Great Lakes UK Limited
Great Wolf Lodge, Chesterton, Bicester

Non Material Amendment (S.96a) Application
Design Changes

March 2023

This document has been prepared by EPR Architects in support of a Non Material Amendment (NMA) application associated with proposed changes to Applicant ref. 21/04158/F.

Proposed Second Floor Plan Part 7

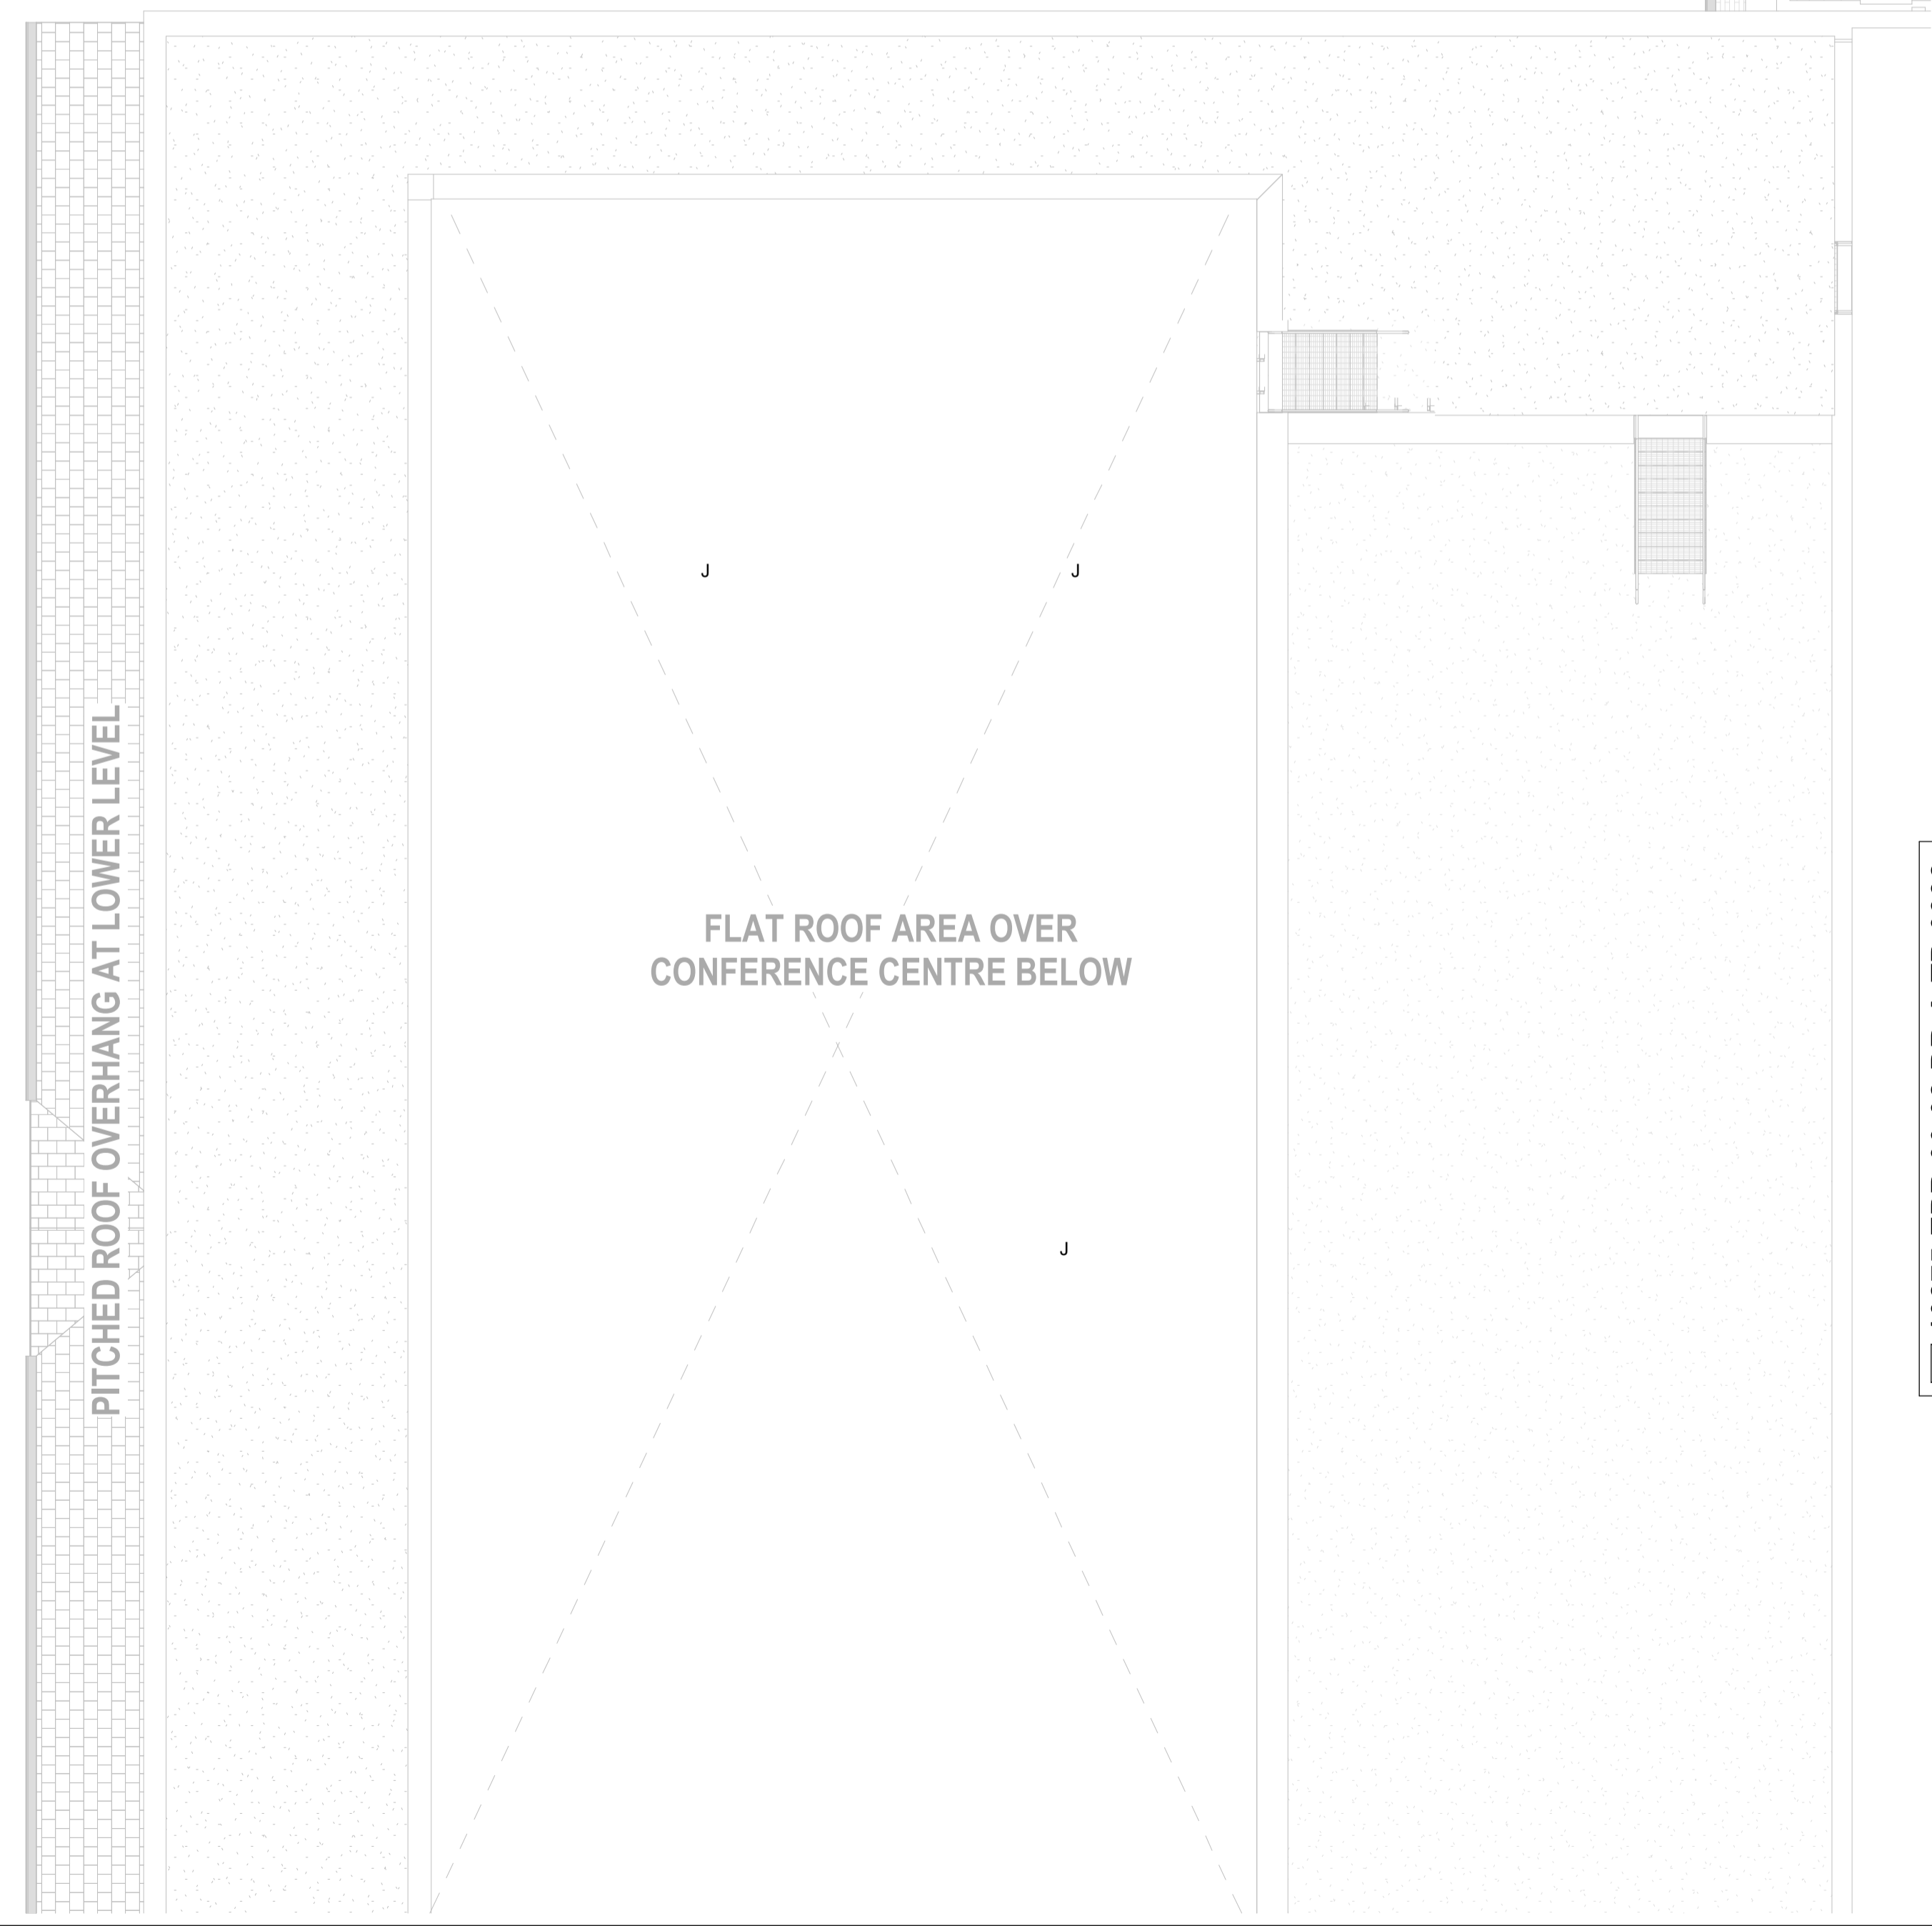
- ① Facades pushed out to allow columns not to protrude into guestrooms.
- ② Corner guestrooms changed to new enlarged types on every floor. 12 no. total rooms affected but no increase in room numbers with this change and no facade changes.
- ③ Façade wall moved down 100mm to align with equivalent wall on left hand side.
- ④ 2x Windows added on levels 1-3 and door added on right on level 1 to provide safer roof access.
- ⑤ 6 No. total additional keys added where shown on levels 1-3. Total guestroom count to be 504.
- ⑥ Replace windows in corner rooms (where there were two windows in room) to recessed reveal detail.
- ⑦ Adaptable and hoist provisions to be installed post completion when required.

Proposed Third Floor Plan Part 7

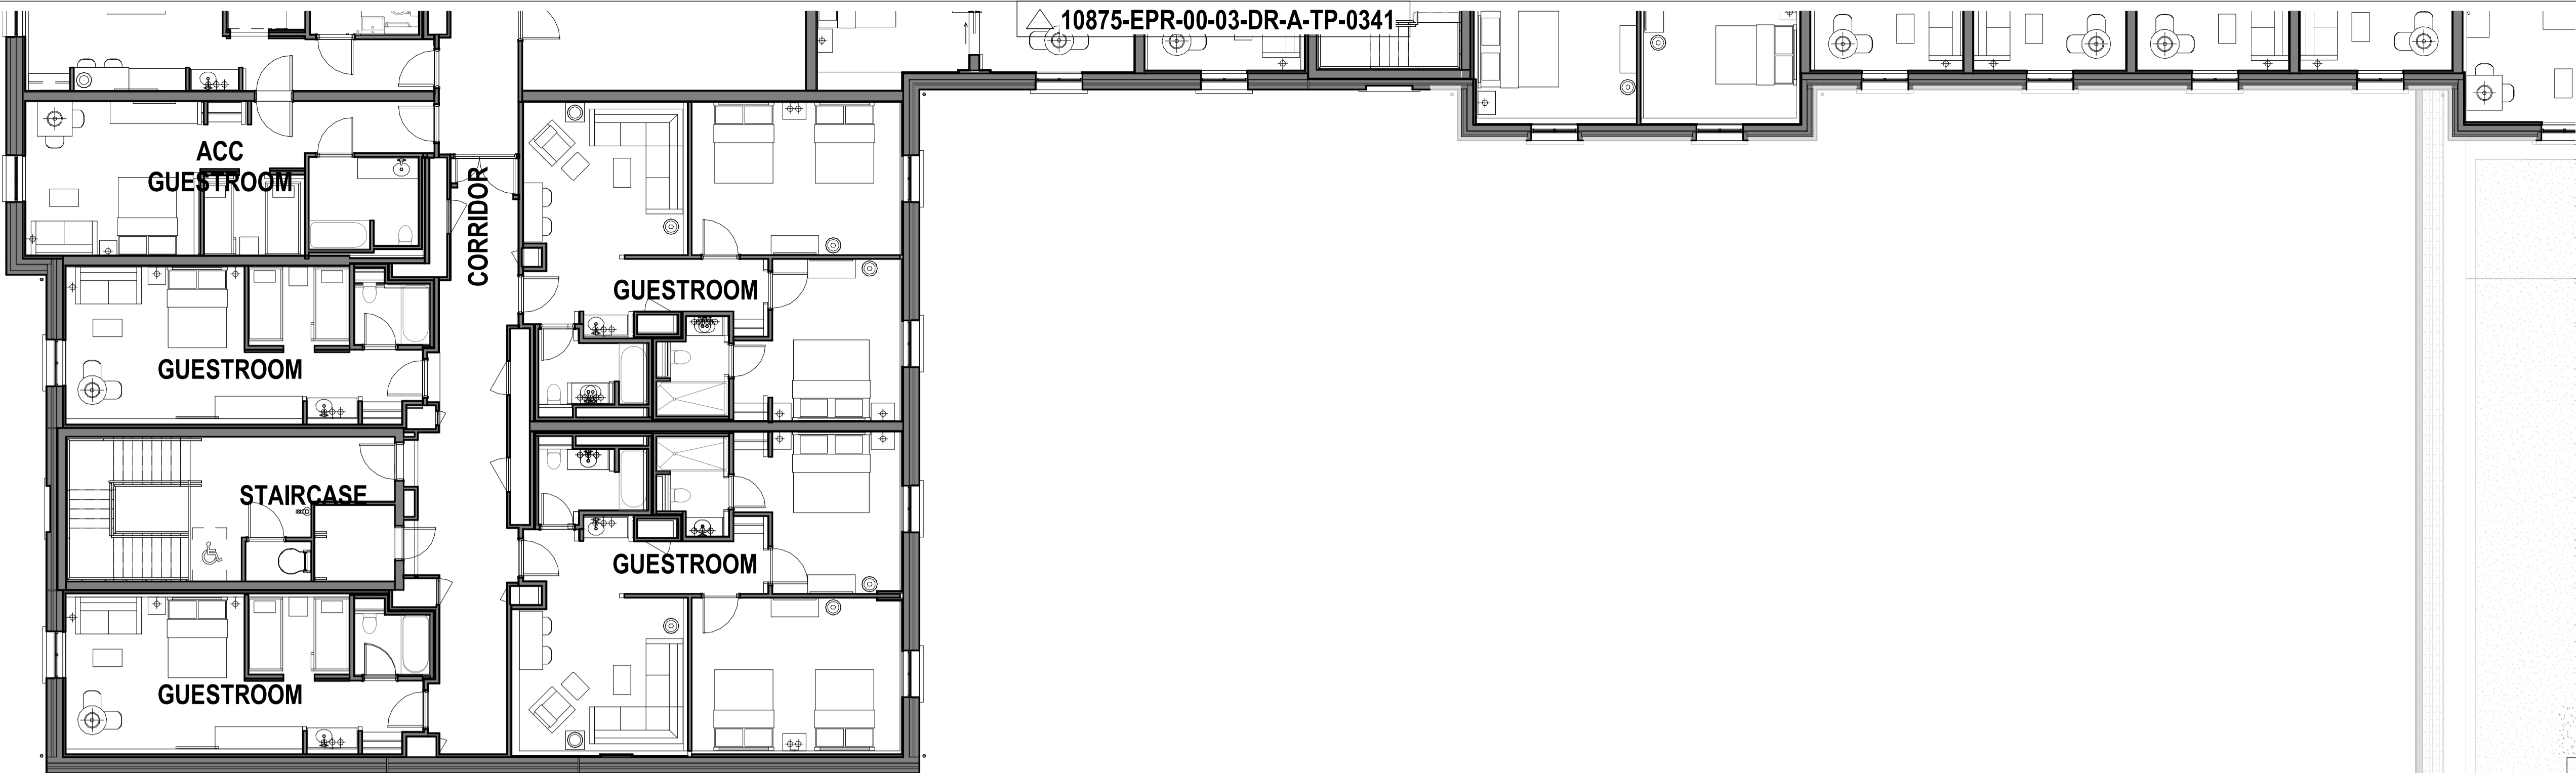
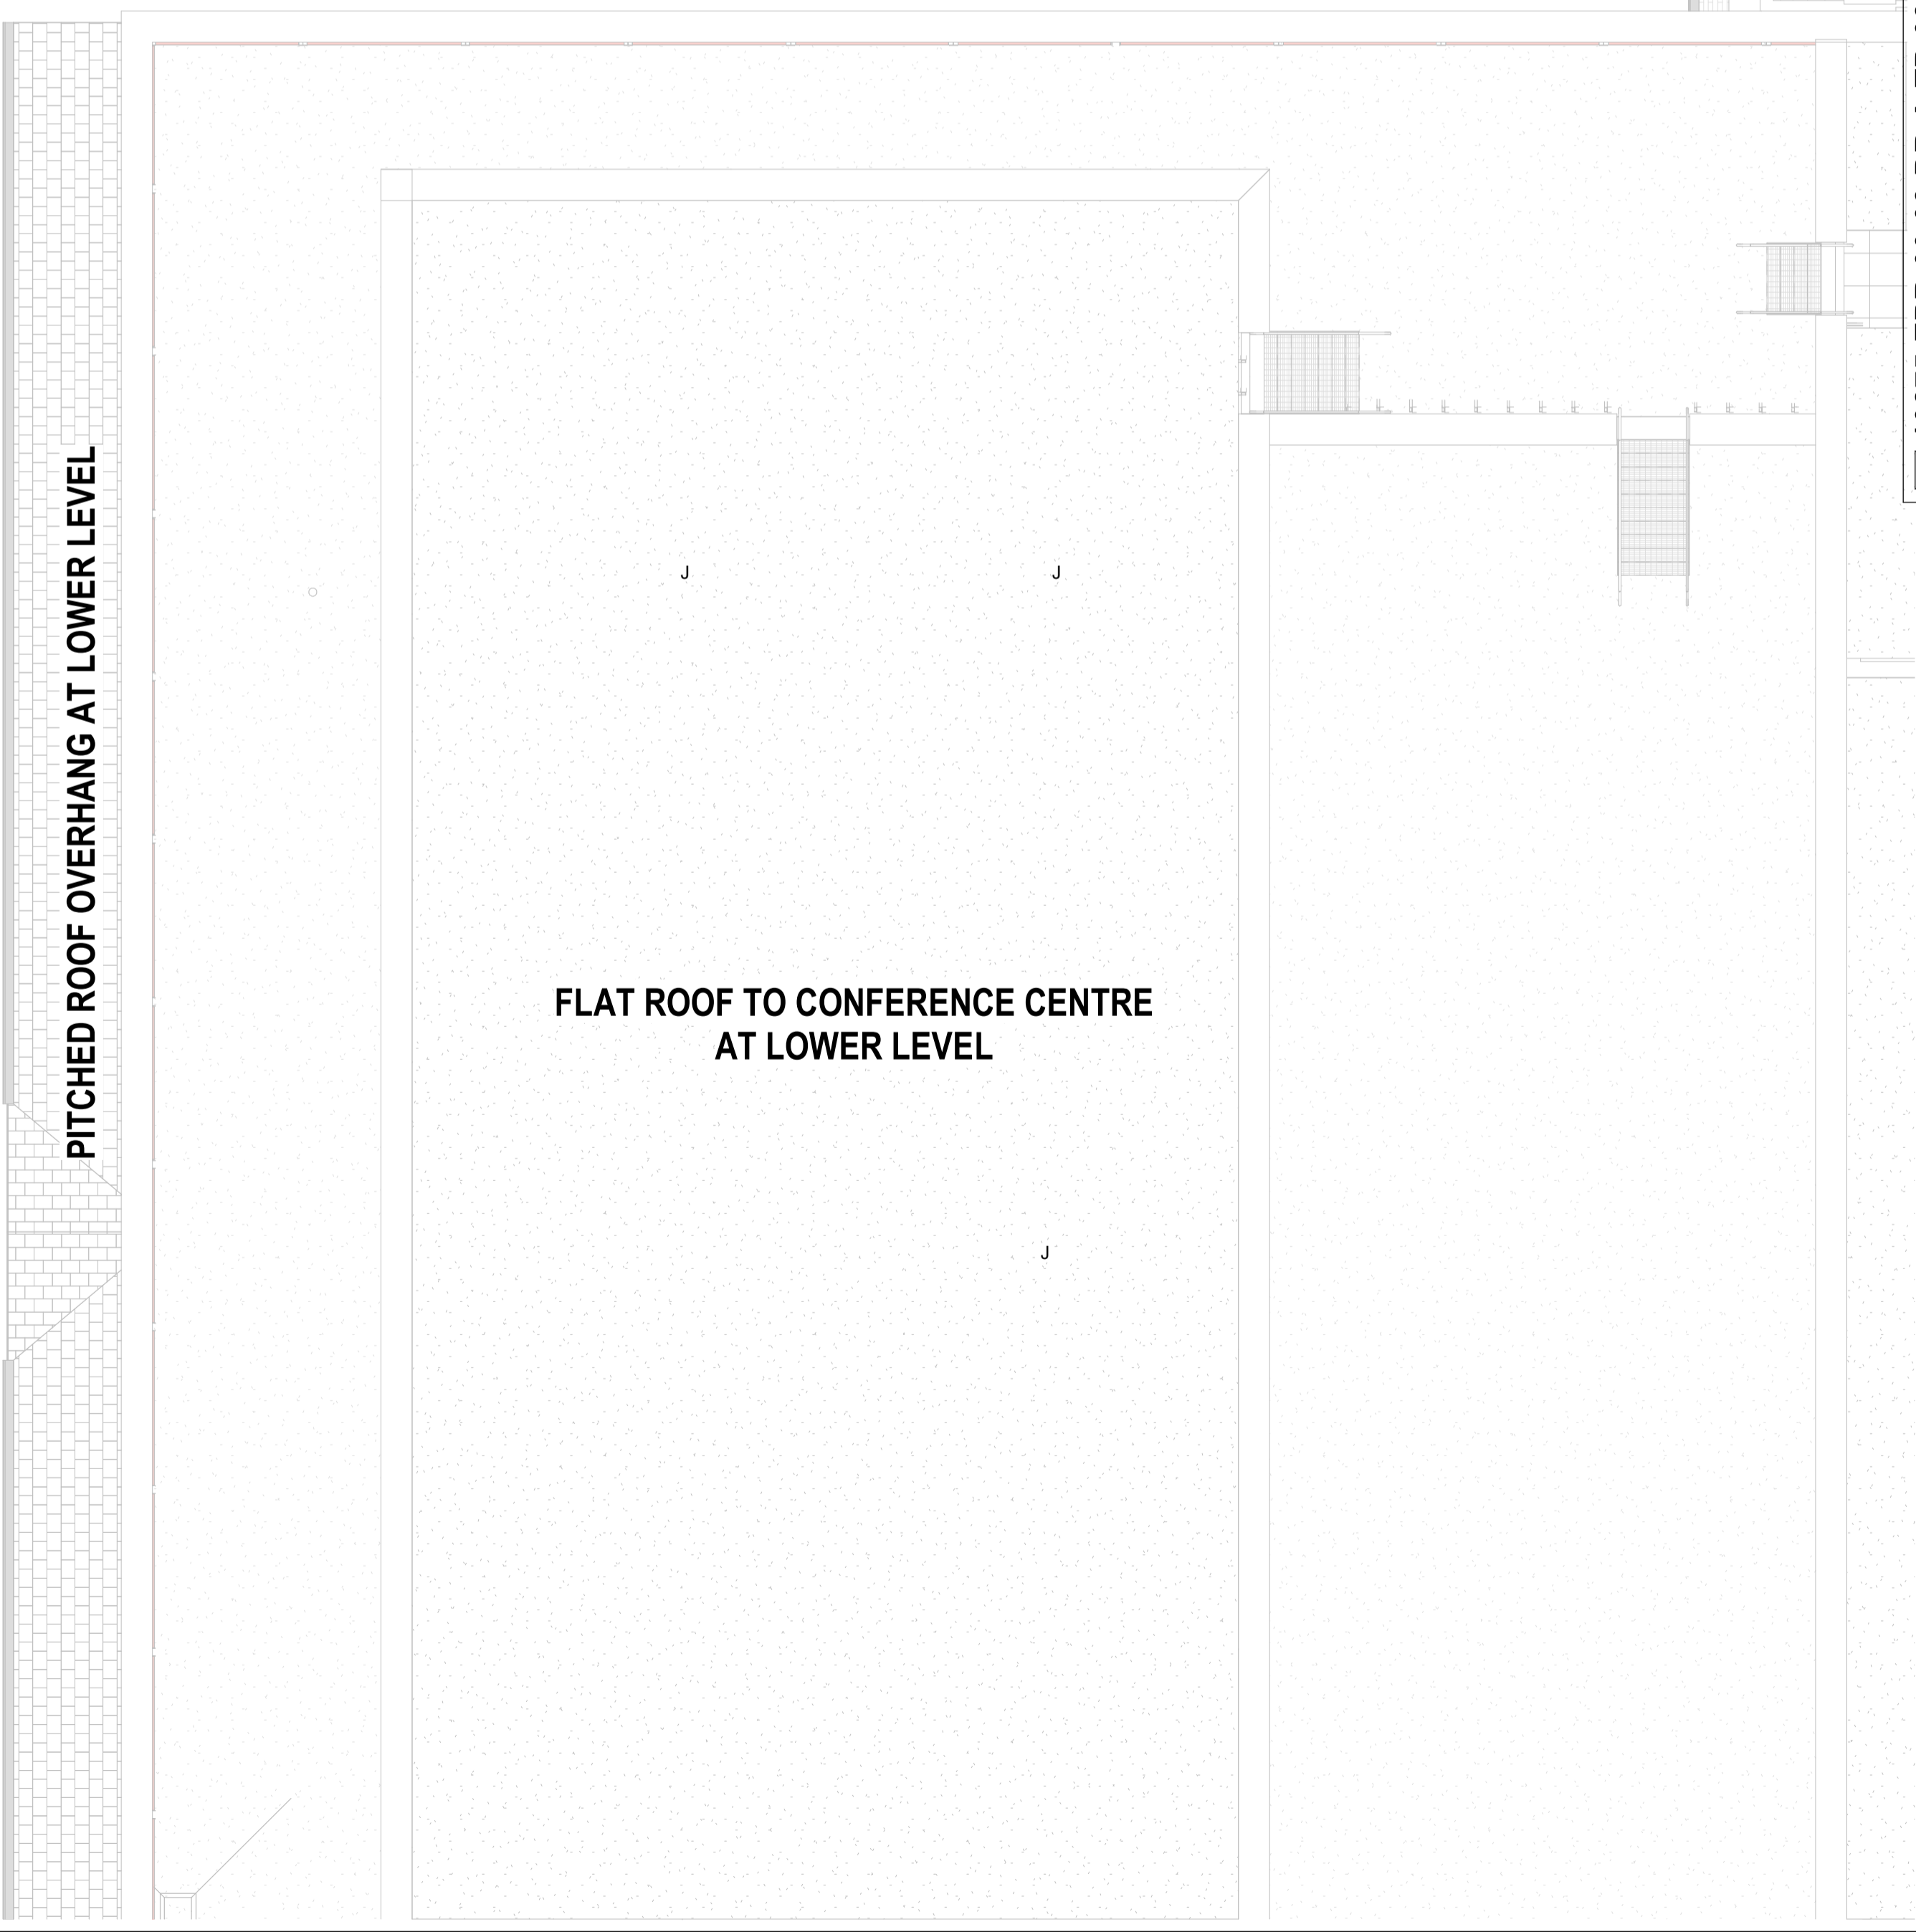
- ① Facades pushed out to allow columns not to protrude into guestrooms.
- ② Corner guestrooms changed to new enlarged types on every floor. 12 no. total rooms affected but no increase in room numbers with this change and no facade changes.
- ③ Façade wall moved down 100mm to align with equivalent wall on left hand side.
- ④ 2x Windows added on levels 1-3 and door added on right on level 1 to provide safer roof access.
- ⑤ 6 No. total additional keys added where shown on levels 1-3. Total guestroom count to be 504.
- ⑥ Window heights and sill height updated to avoid clash with reduction in roof line and weathering detail.
- ⑦ Adaptable and hoist provisions to be installed post completion when required.
